Gatwick Northern Runway Project DCO (Project Reference: TR020005)

Deadline 2 Submission (26 March 2024)

Crawley Borough Council (IP Ref: GATW-AFP107), West Sussex County Council (IP Ref: 20044715), Horsham District Council (IP Ref: 20044739) and Mid Sussex District Council (IP Ref: 20044737)

Comments on the Applicant’s Deadline 1 Submission *Development Consent Order - Schedule of Changes* [REP1-005]

Section 6 - Airport Way Westbound Diverge To North Terminal Roundabout

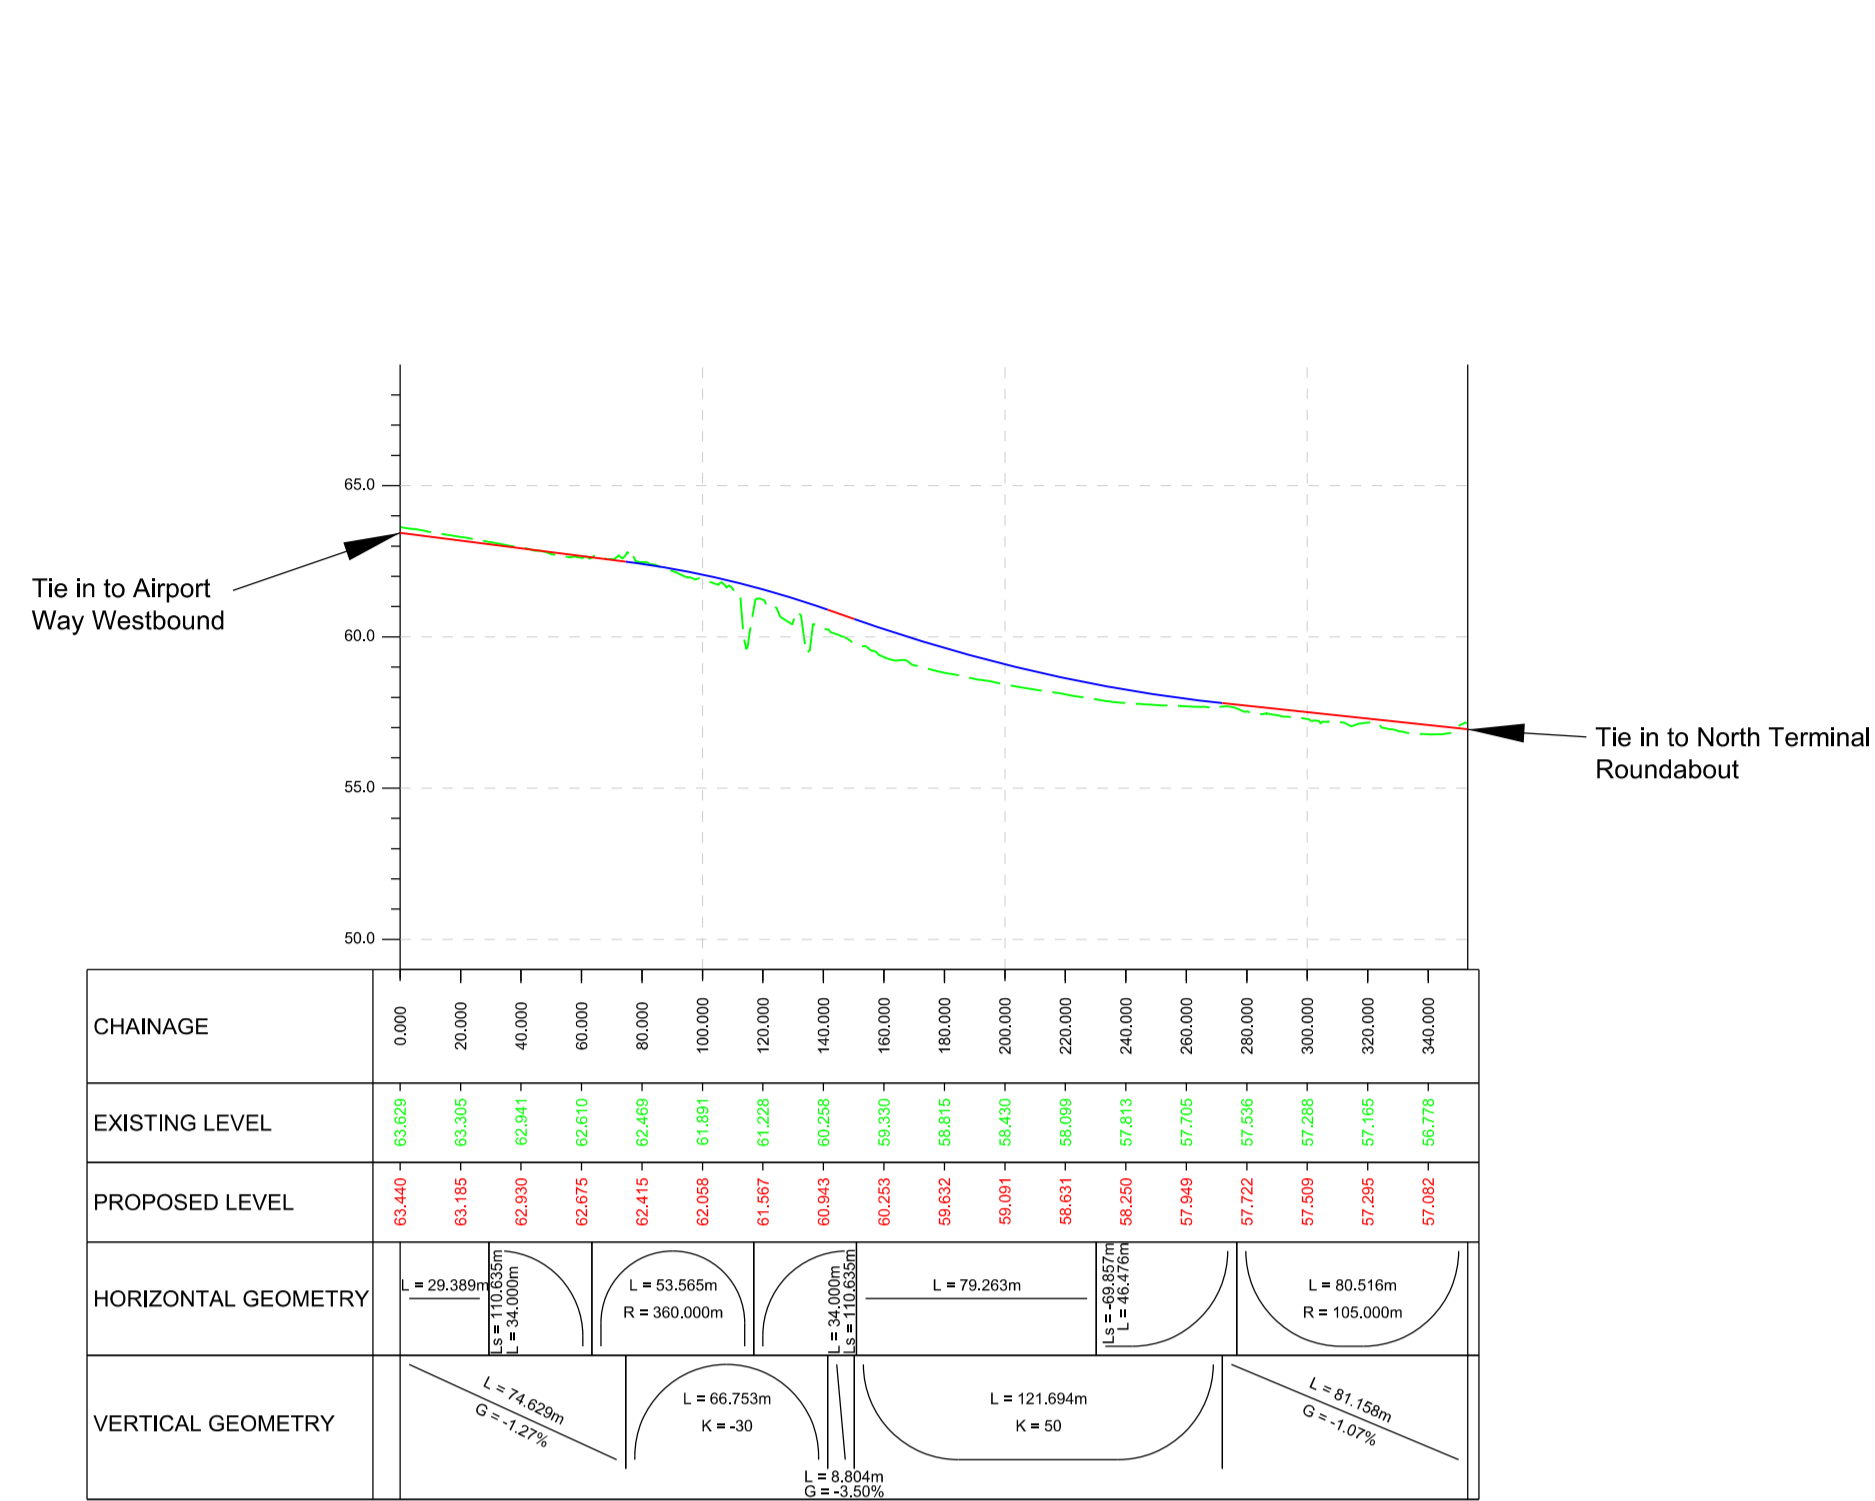
- 2.35 Additionally, as previously stated in the authority’s comments on the draft DCO there appears to be an error in relation to page 66 of the draft DCO. The draft DCO refers to the A23 London Road Diverge to North Terminal Roundabout as being shown by green striped hatching (indicating National Highways responsibility) but on the associated Rights of Way and Access Plans it is shown as a blue hatched plan (indicating Local Highway Authority maintained). These latest Rights of Way and Access Plans continue to indicate the A23 London Road Diverge to North Terminal Roundabout as Local Highway Authority maintained. However, WSCC would envisage that the A23 London Road Diverge to North Terminal Roundabout would be managed and maintained by National Highways and therefore clarification should be provided by the Applicant and the plans amended to accord with the wording in the draft DCO.
